Engineers Comments Regarding Surface Water Drainage

Application Reference:	Y/71/25/DOC	Reviewer Reference:	ADC/EXT4
Planning Officer:	Simon Davis	Date of Review:	17/03/2026
Site Name:	Land at Stakers Farm North End Road Yapton		
Application Description:	Approval of details reserved by condition imposed under Y/44/17/OUT relating to condition 18-updated copy of management manual for SuDS system.		
Assessment Number:	2 of 2

Application Reference: Y/71/25/DOC Site Name: Land at Stakers Farm North End Road Yapton	Initial Issue Date: 29/12/2025 Issue Date: 17/03/2026 Reviewer Reference: ADC/EXT4
--	--

Job Title		
LAND AT STAKERS FARM, YAPTON		
Drawing Title		
DRAINAGE CONSTRUCTION DETAILS (SHEET 1 OF 2)		
Client		
DANDARA LIMITED (SOUTHERN)		
Scale	Date	Designed
AS SHOWN	JUL 20	CJL
Drawn	Checked	Approved
CJL	SW	JHM
Job No	Drawing No	Rev
18-204	YAP-180-030	C2

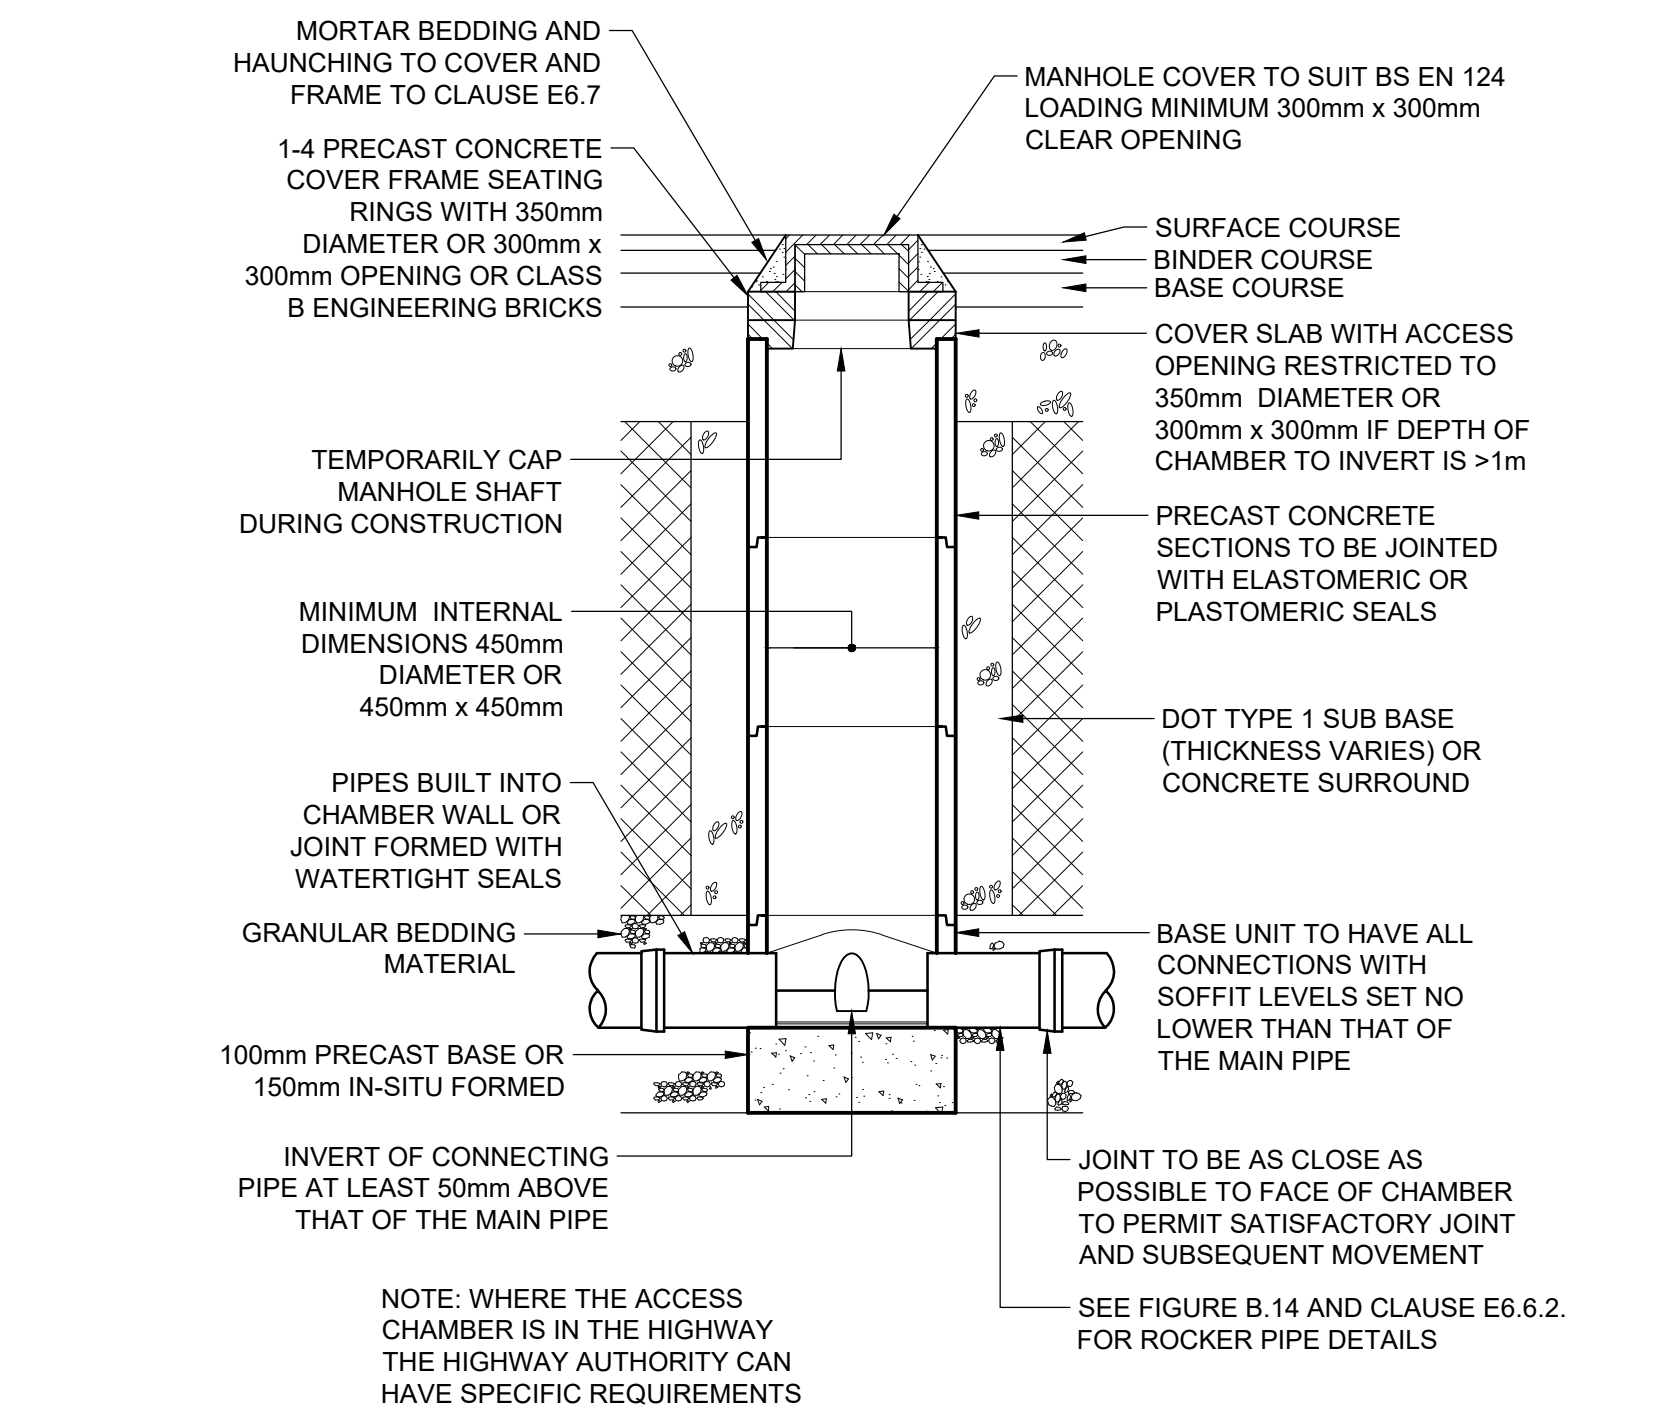
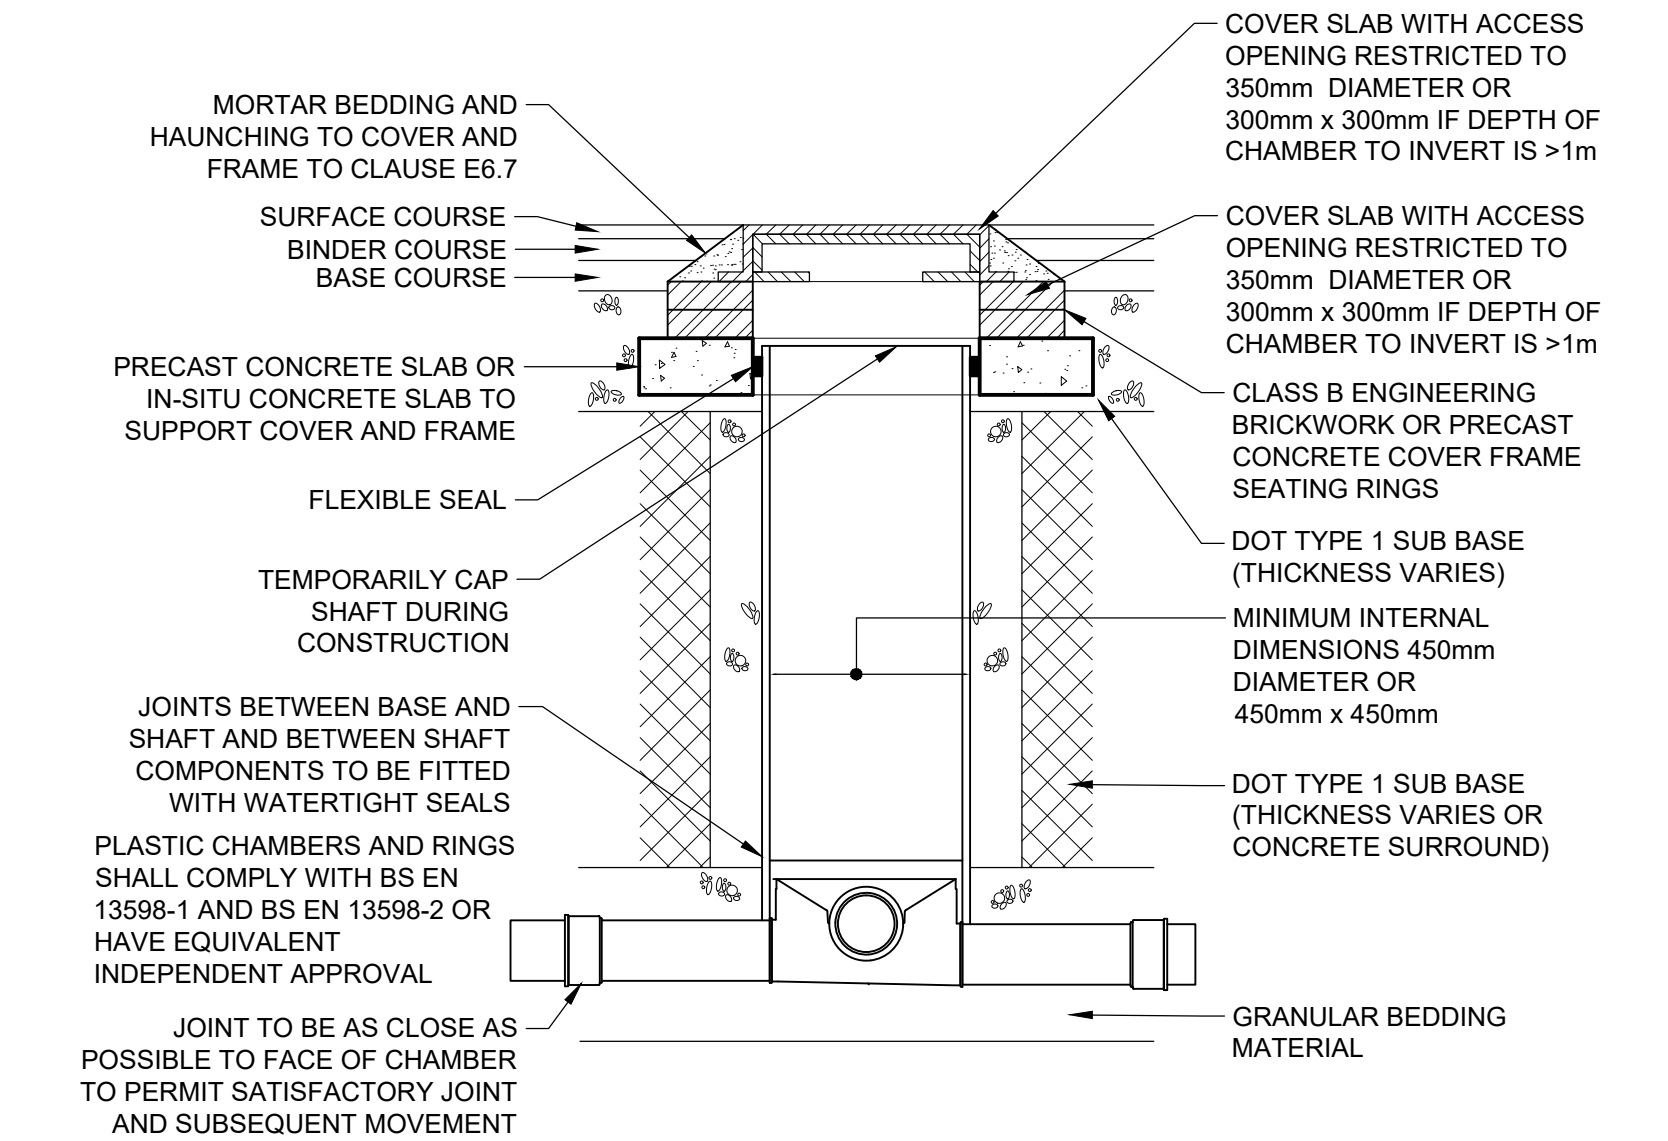
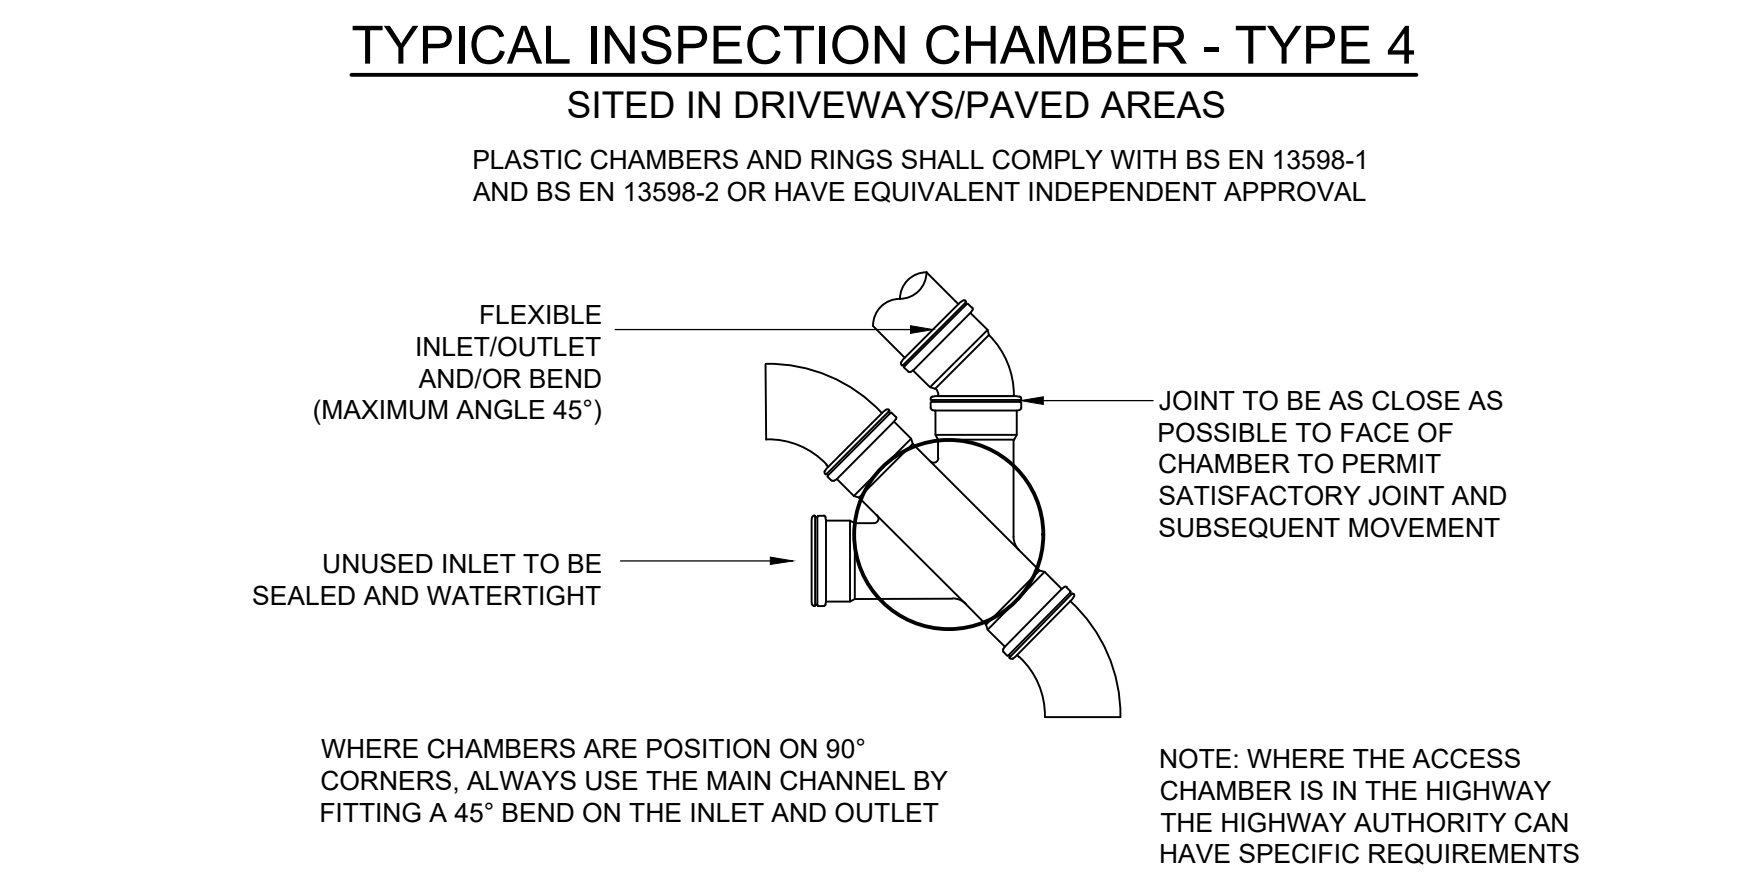
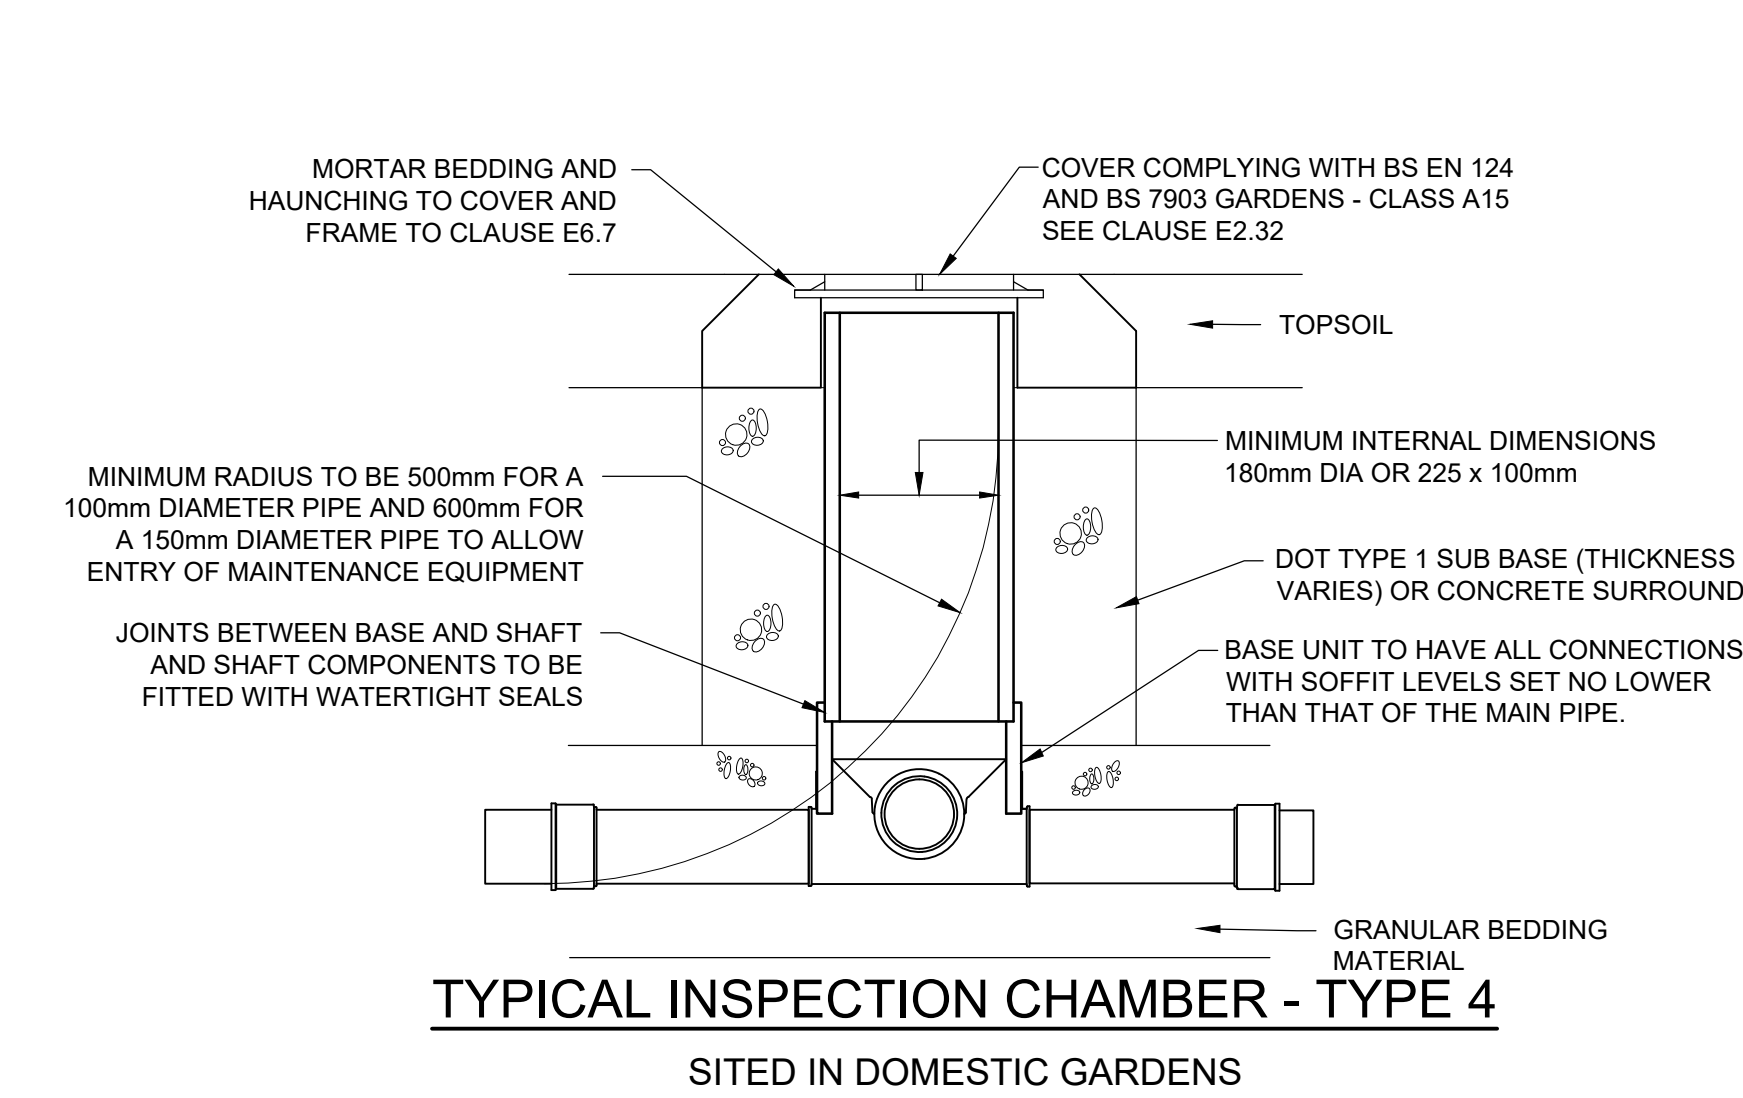
2.	The maintenance plan only appears to include the asbuilt survey, the full set of approved design drawings must be included with the Maintenance and Management Plan	Full set of approved design drawings included.	Only the drainage layout plans appear to have been included in the updated Maintenance Plan report. All drawings including drainage

construction details need to be included		
3.	Please provide a plan showing maintenance responsibility should be included in the report	Additional drawing YAP-130-090 provided that differentiates the responsibility between management company and respective householders.	Thank you for providing this but please add a key to this drawing to identify which the red colour and blue colour drainage relates to please
